R/215/25/HH

From: [REDACTED]
Sent: 16 December 2025 08:59
To: Breezie Allwright <Breezie.Allwright@arun.gov.uk>
Subject: Re: R/215/25/HH

The BLOCK PLAN SHOWS NOT ENOUGH GAP ROOM TO ALLOW BUILDING TO BE MADE , JUST 50MM LEAVING SMALL GAP, DOES NOT SEEM MUCH FOR PROPOSED PLAN

Drawing:  
**Plans and elevations as proposed**

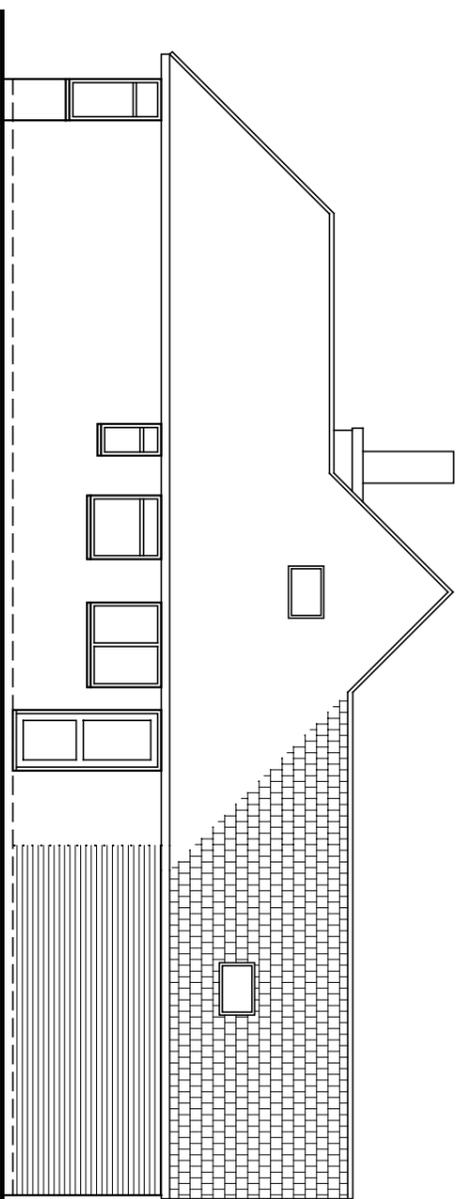
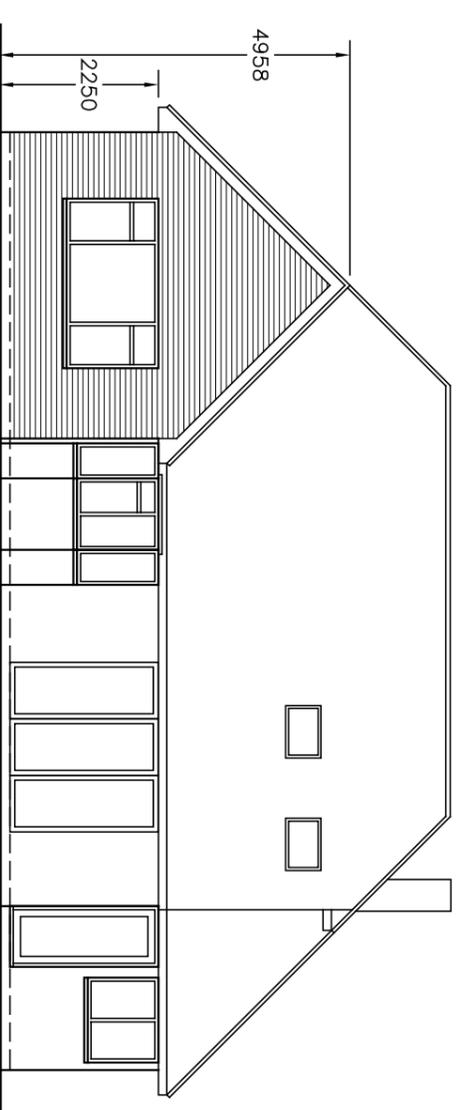
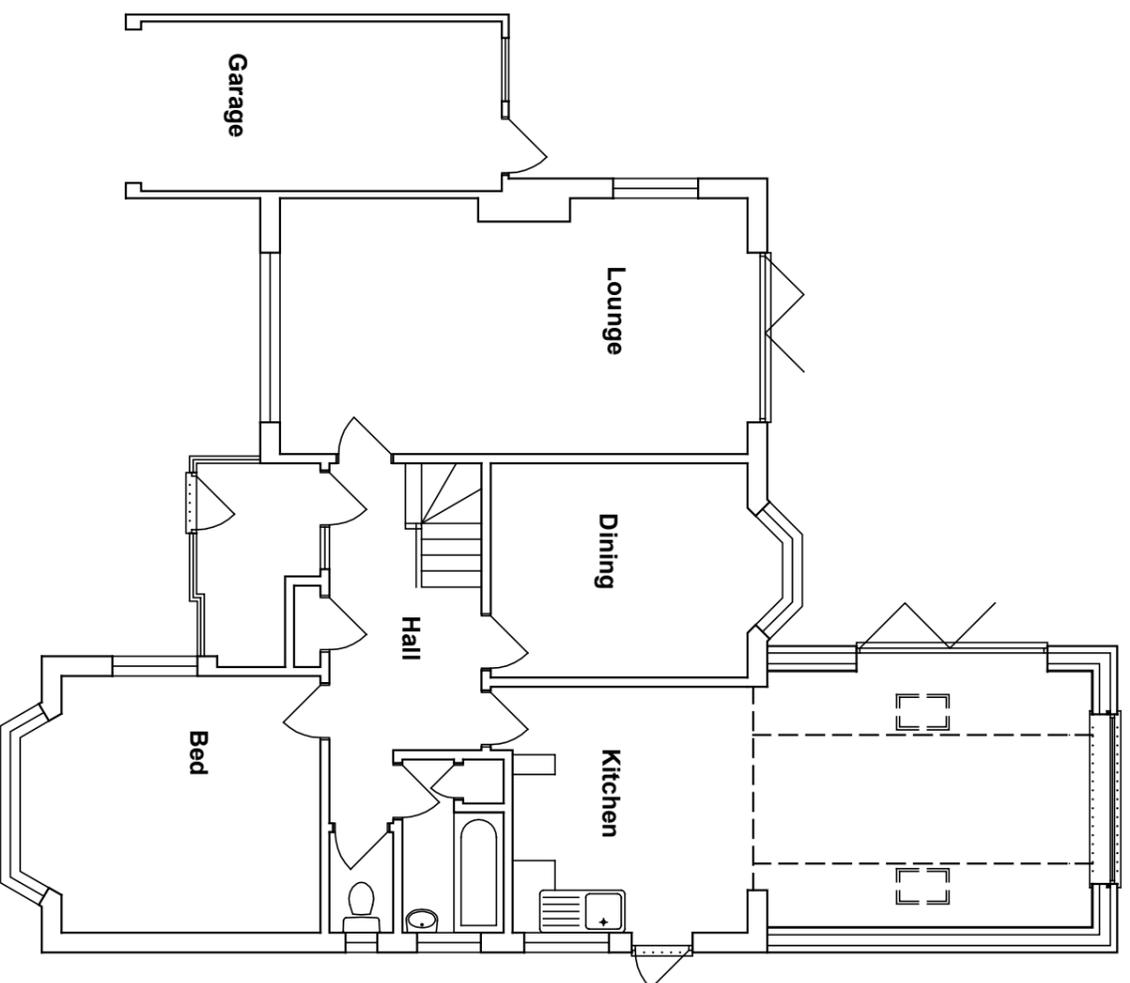
The extension overshadows or overlooks a J WOODS 1 EVELYN AVE ,key windows TO MAIN LIVING AREA AS HEIGHT IS TO CLOSE

Proposed plans will leave"21 ft of brick wall and gutter " , running along my south border view,

PLEASE MENTION MY TOTAL OPPOSITION ALSO TO HEIGHT

planned extension will block sunlight to main living are and also conservatory,
my south border where light comes from is where thompsons plan to build ,wall and gutter will be high enough to make this occur
